# CITY OF ALBUQUERQUE

January 31, 2014

RE: **SCA 9<sup>th</sup> & Tijeras**  
**Grading and Drainage Plan**  
**Engineers Stamp Date 12/26/13 (J14-D114)**

ENGINEER'S SEAL 12/26/13 DAVID SOULE P.E. #14522	SCA - 9TH AND TIJERAS	DRAWN BY DEM
	GRADING AND DRAINAGE PLAN	DATE 12-23-13
 1000 CENTRAL AVENUE SUITE 301 ALBUQUERQUE, NM 87108 (505) 672-2222		SHEET # XX
		JOB # XXXX

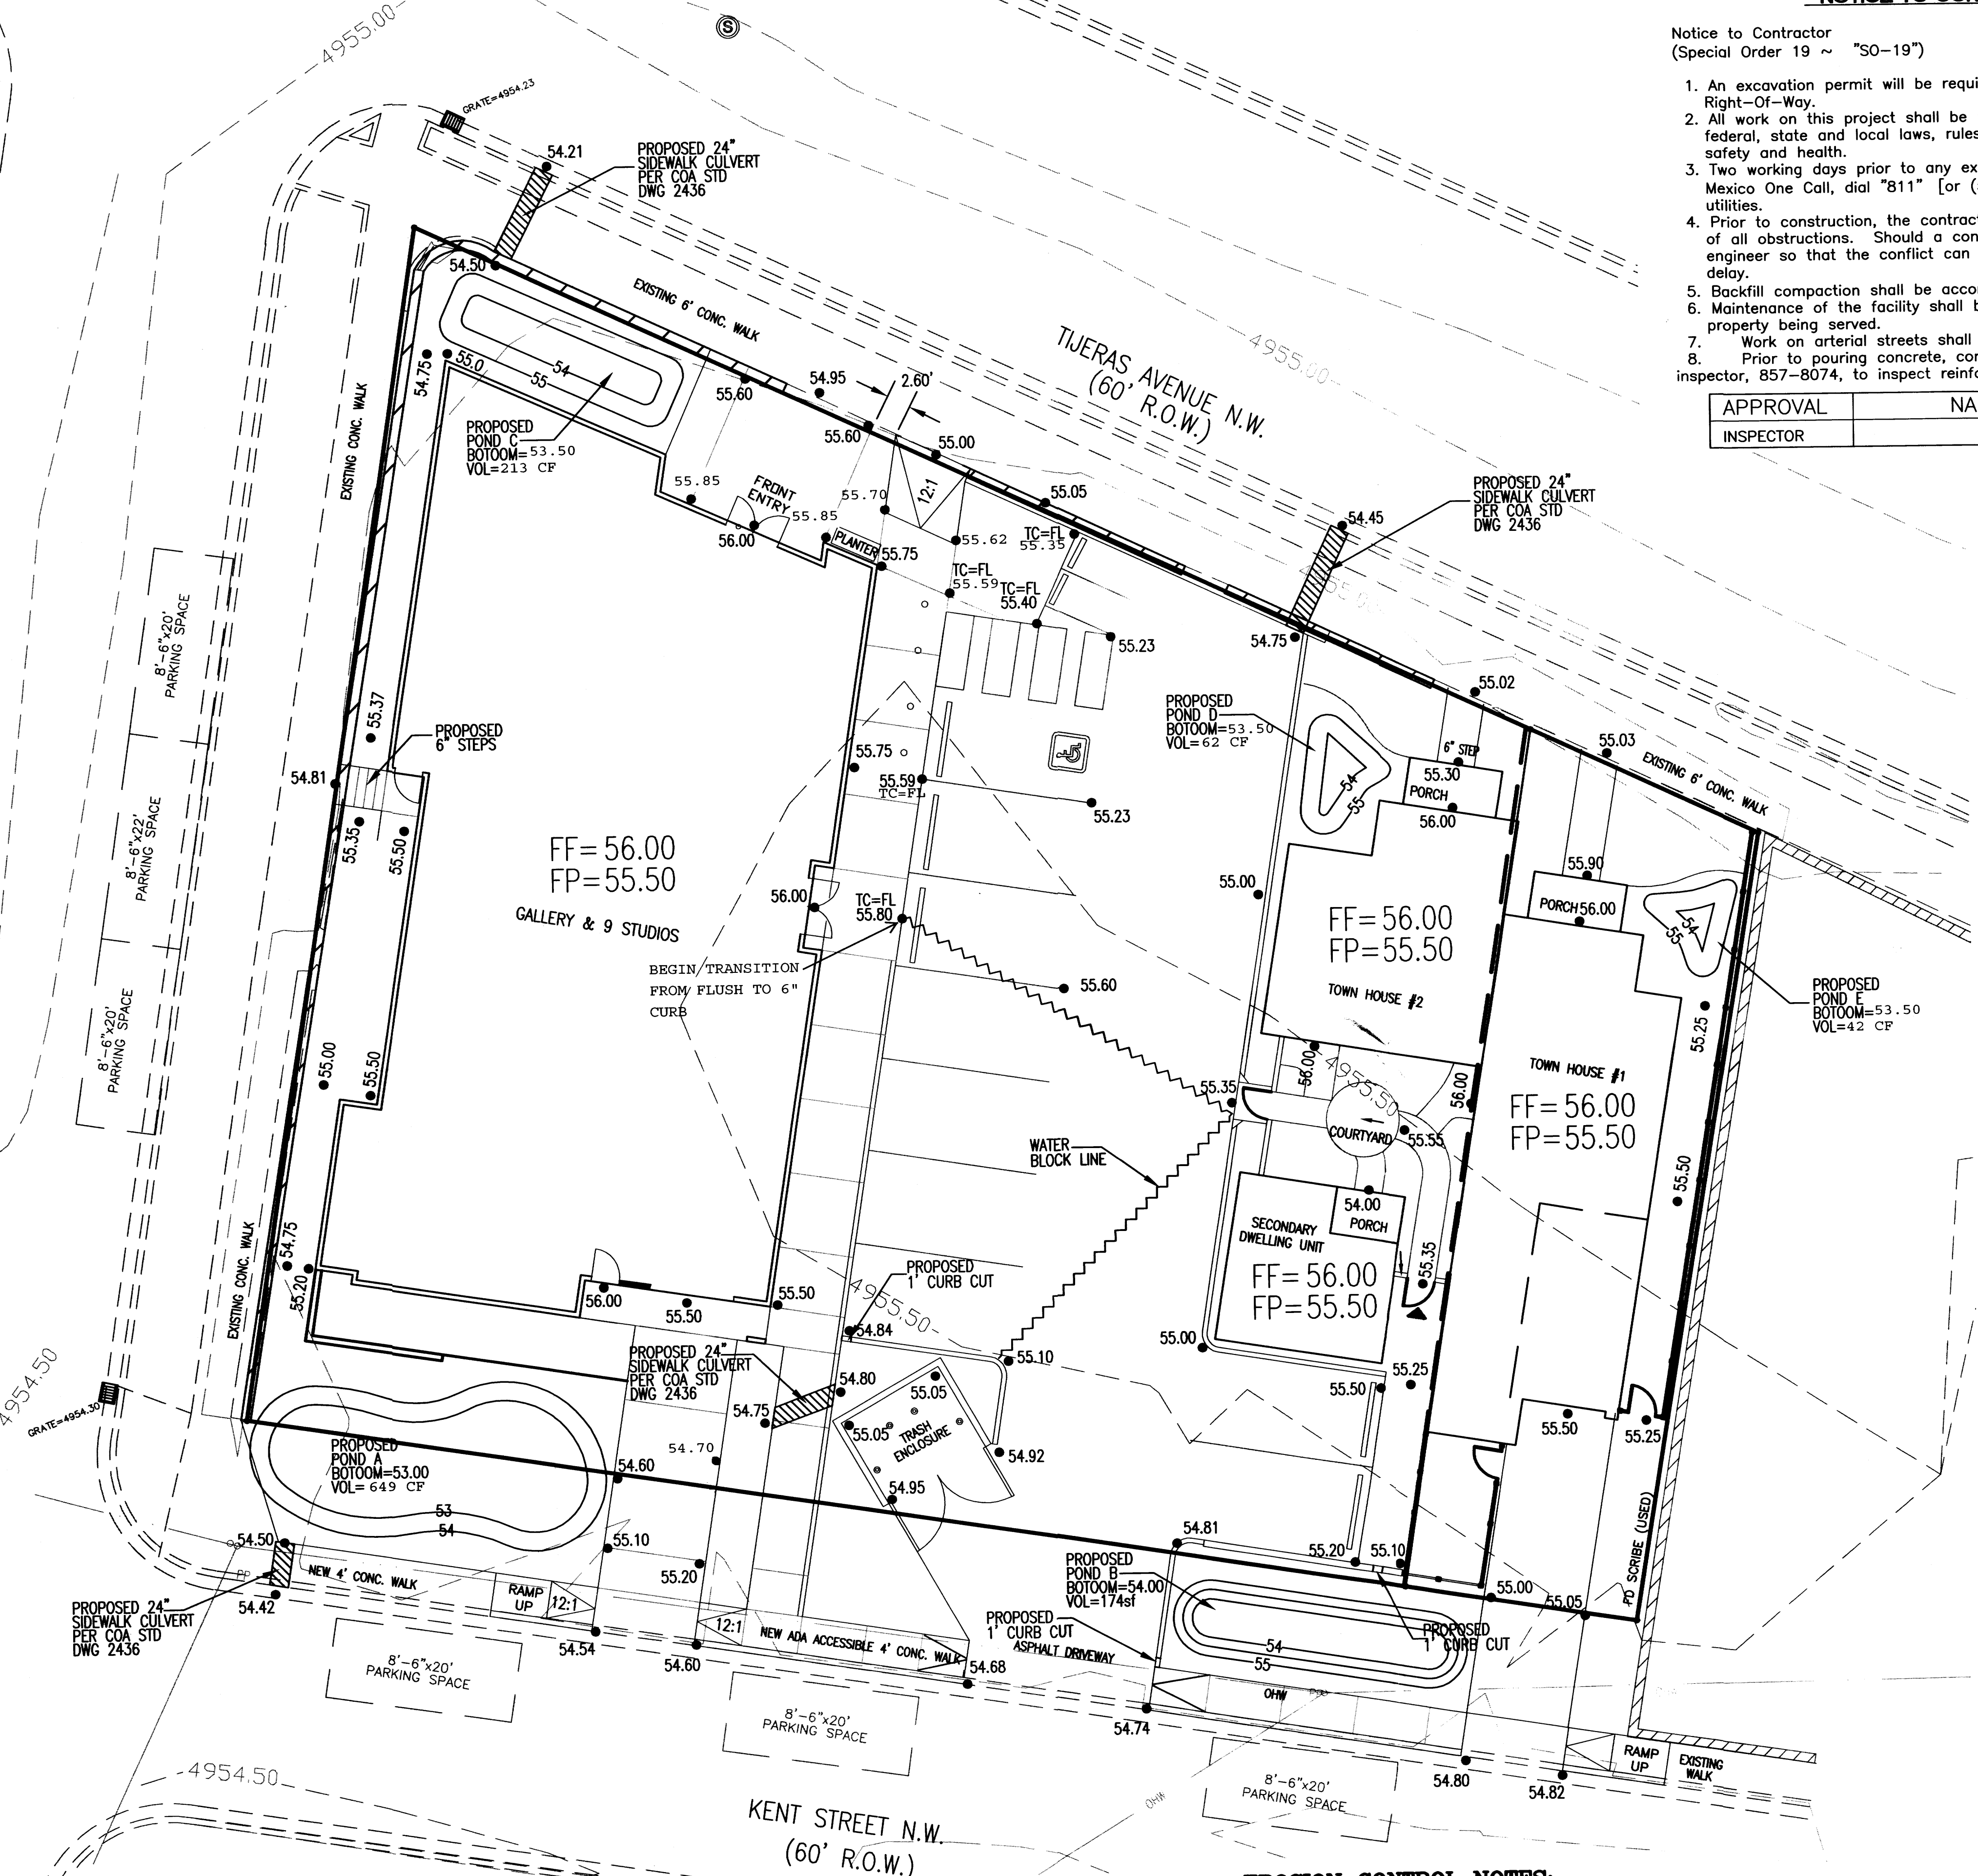
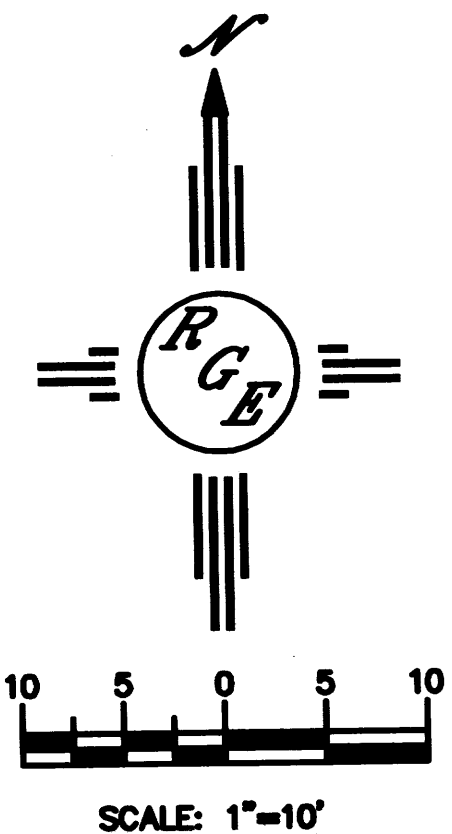
- Show all roof flows.
- All drive pads should be shown.
- The ponds in Kent Street are not allowed, for all ponding areas are to be kept onsite and not in any right of way. To rectify this situation the hydrology section suggests that ponding is done in the parking lot with an area drain leading to the back of the grate in Tijeras Ave. or 9<sup>th</sup> St. The placement of this drain and pipe would aid in keeping the required flow release of 2.75 cfs per acre. This site is allowed to release 1.21cfs.
- A water block is needed on Kent Street.
- Do to the odd placement of the trash enclosure the hydrology section would like to see the approved site plan.
